Re: Santa Fe Tow Lot #13

8101 Jacs Ln., NE

**Traffic Circulation Layout**

Engineer's/Architect's Stamp dated 6-21-16 (D16-D002A5)

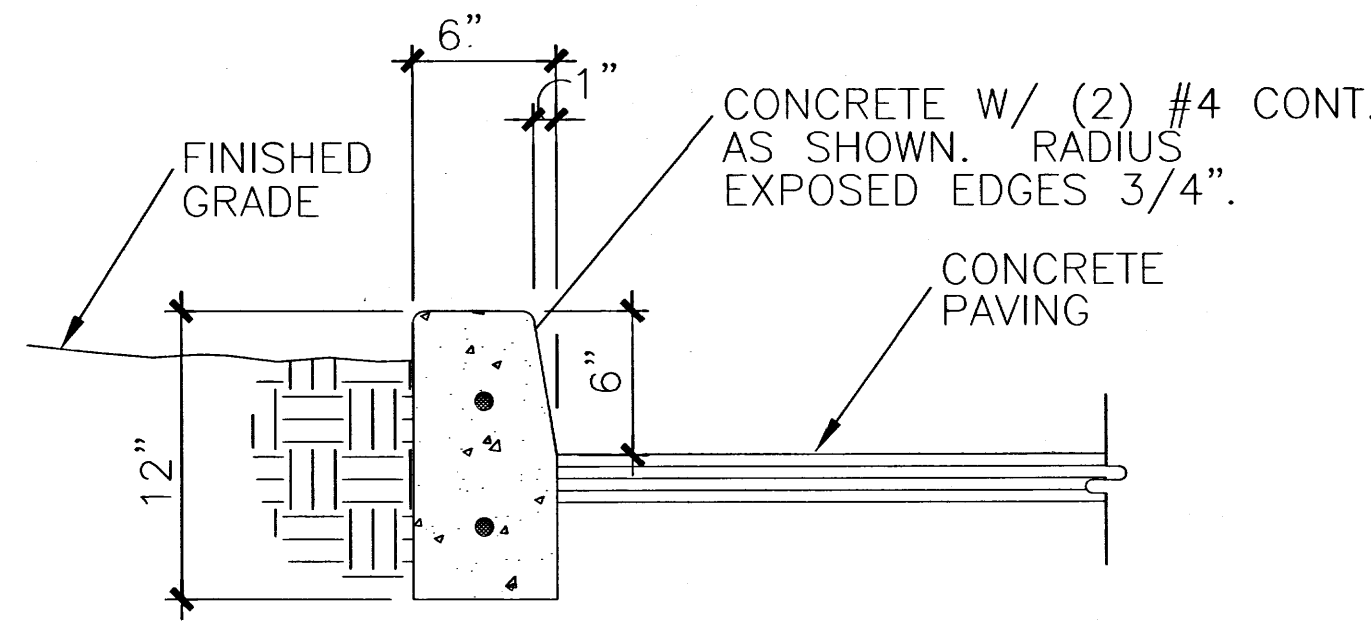
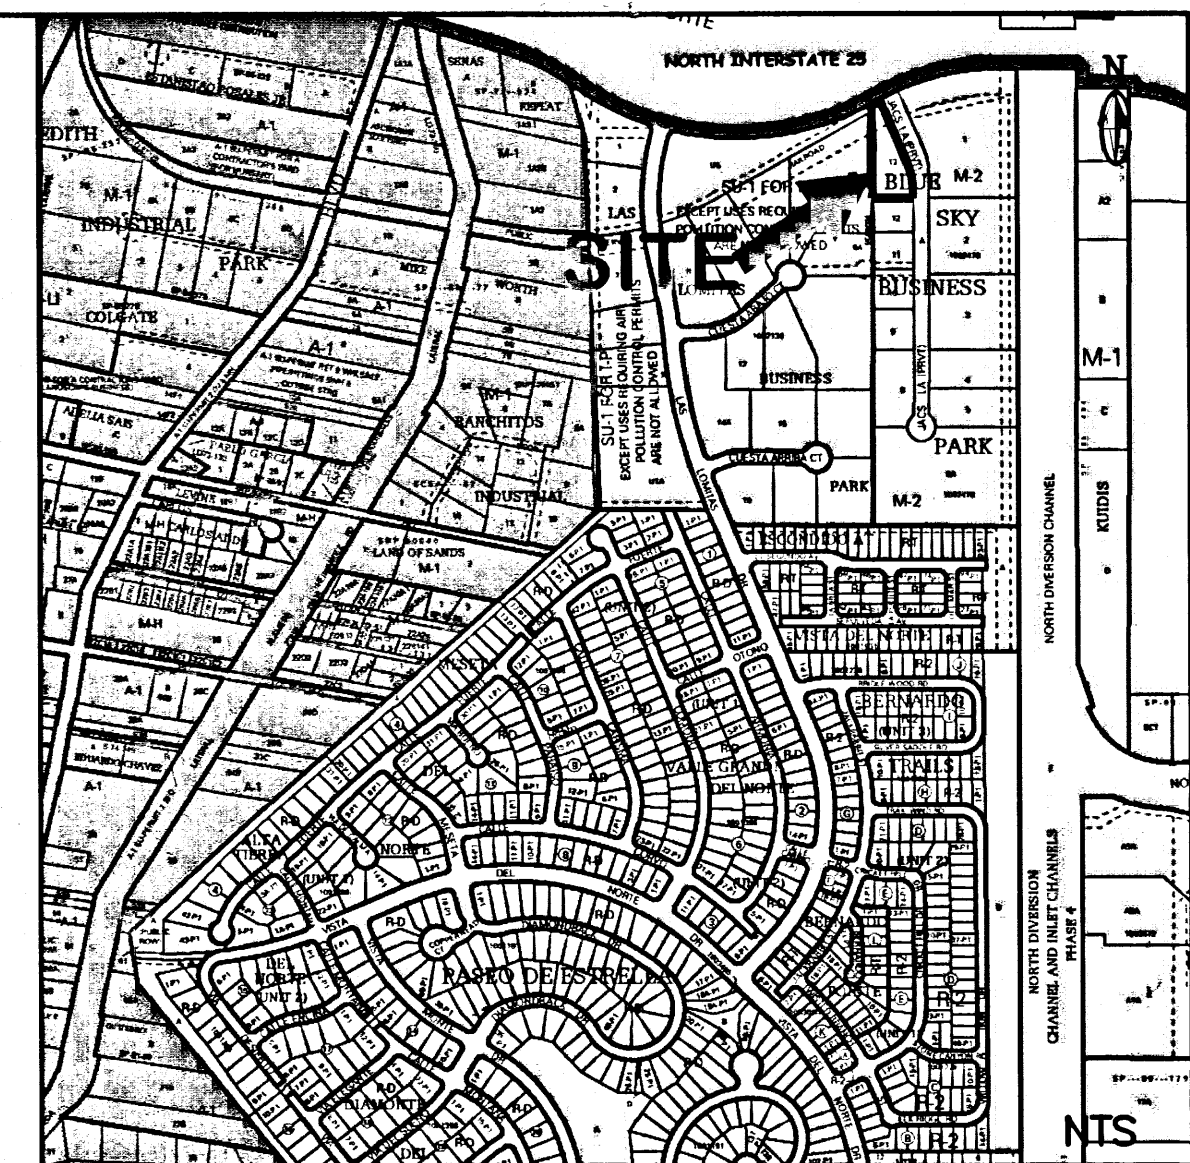
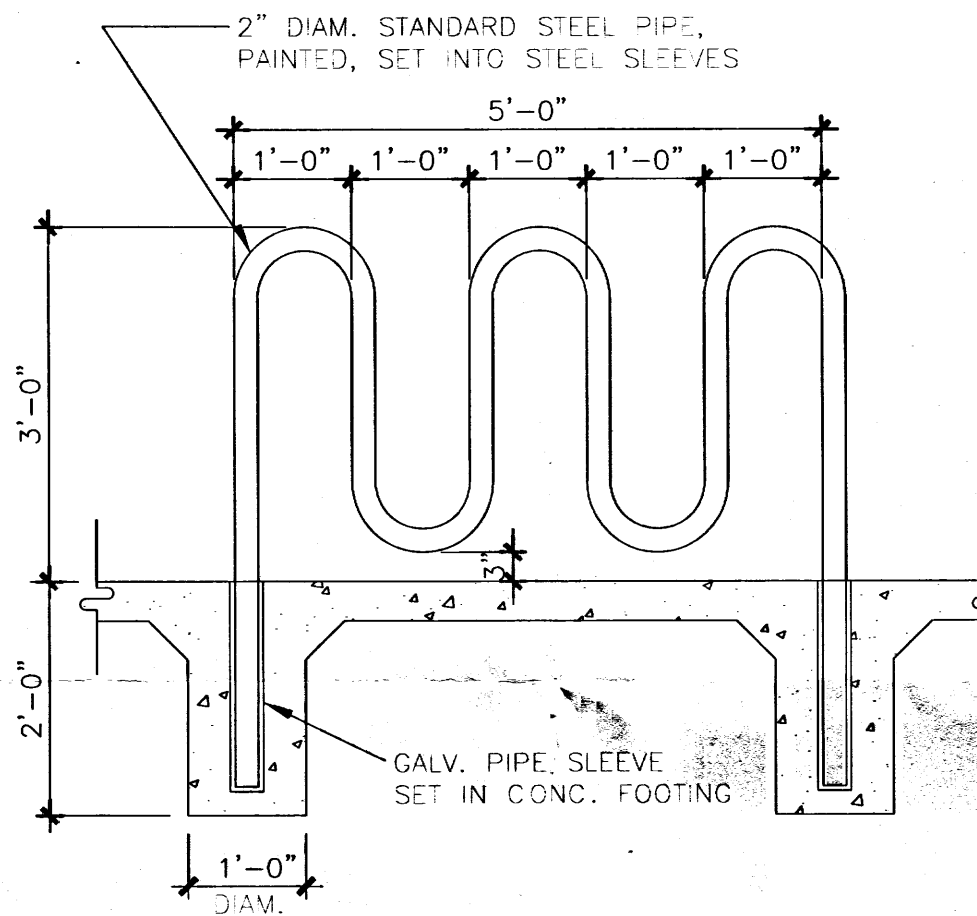
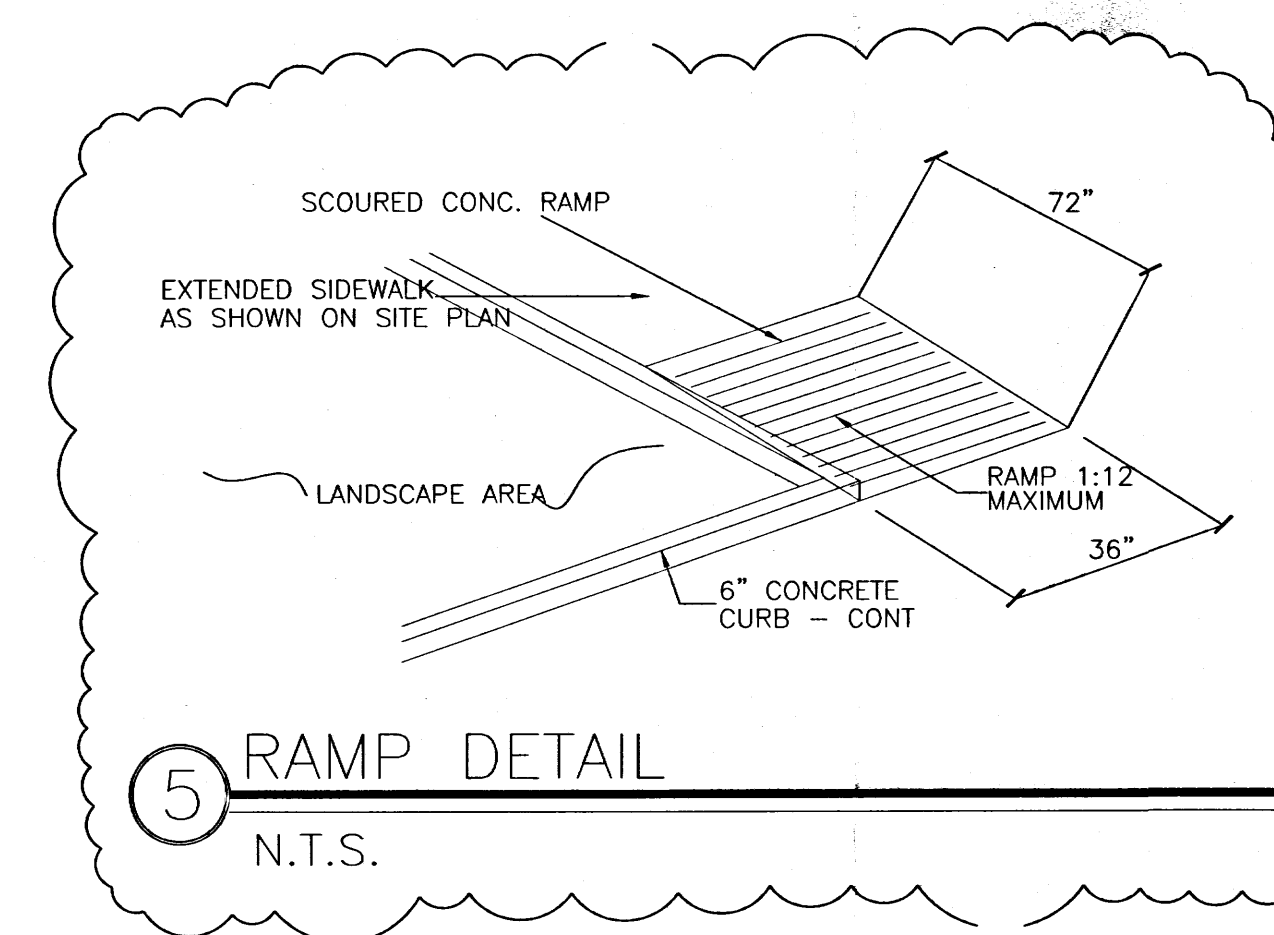
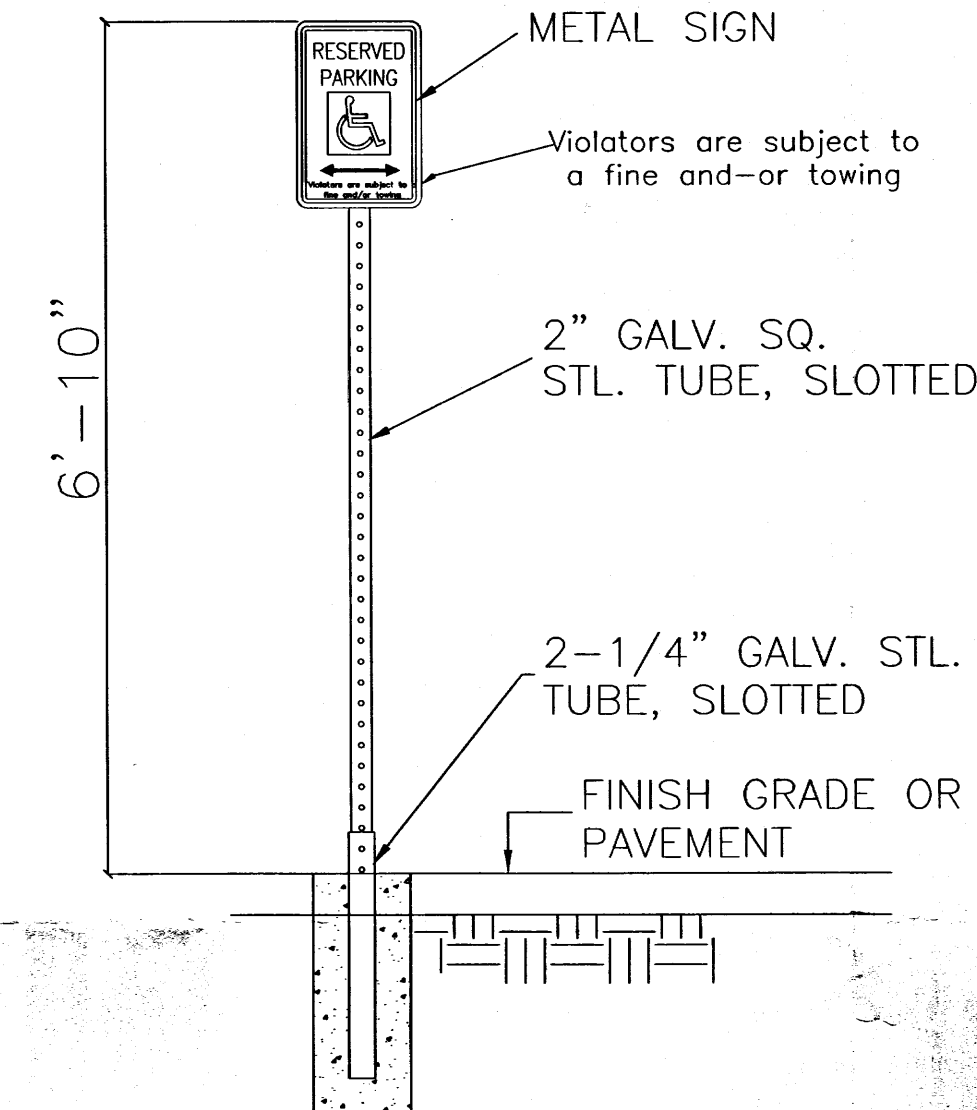
- 1. Please identify all existing buildings, doors, sidewalks, curbs, drive pads, walls and anything that influences the parking and circulation on the site.
- 2. Show all drive aisle widths and radii.

- 3. Please detail the width of the proposed drive pad.
- 4. Please detail the ADA ramps and sidewalk from the Public R.O.W.

5. Per the DPM, a 6 ft. wide ADA accessible pedestrian pathway is required from the public sidewalk to the building entrances. Please clearly show this pathway and provide details.

- 6. Per the DPM, a 6 ft. wide ADA accessible pedestrian pathway is required from the HC parking stall access aisles to the building entrances. Please clearly show this pathway.
- 7. Provide a min 6" or max 8" high concrete barrier curb or other acceptable barrier between landscaping and parking areas and/or drive aisles.
- 8. Design delivery vehicle route needs to be shown.
- Service vehicle and/or refuse vehicle maneuvering must be contained on-site; provide a copy of refuse approval.

10. Please provide a sight distance exhibit (see the *Development Process Manual*, *Chapter 23, Section 3, Part D.5 Intersection Sight Distance*). Please show this detail for the entrance/exit on Jacs Ln.

- 11. Please add the following note to the clear sight triangle: "Landscaping and signage will not interfere with clear sight requirements. Therefore, signs, walls, trees, and shrubbery between 3 and 8 feet tall (as measured from the gutter pan) will not be acceptable in this area."
- 12. Please include two copies of the traffic circulation layout at the next submittal.

- 2. All drive aisle widths and radii have been shown.
- 3. The width of the proposed drive pad has been shown.
- 4. The ADA ramps and sidewalk from the public ROW is per DWG. 2425 and the detail has been added to the plan.
- 5. A 6 ft. wide ADA accessible pedestrian pathway was added from the public sidewalk to the building entrance and is clearly shown and detailed.
- 6. A 6 ft. wide ADA accessible pedestrian pathway has been added from the HC parking stall access aisle to the building entrance and the pathway is clearly shown.
- 7. A barrier with note is provided between landscaping and parking areas and/or drive aisles.
- 8. Design delivery vehicle route has been added/shown on the plan.

- 9. Service vehicle and/or refuse vehicle maneuvering is contained on site and owner will provide a copy of refuse approval.
- 10. A sight distance note has been added to the plan per the detail.
- 11. The note has been added to the plan.
- 12. Two copies of the traffic circulation layout are attached.
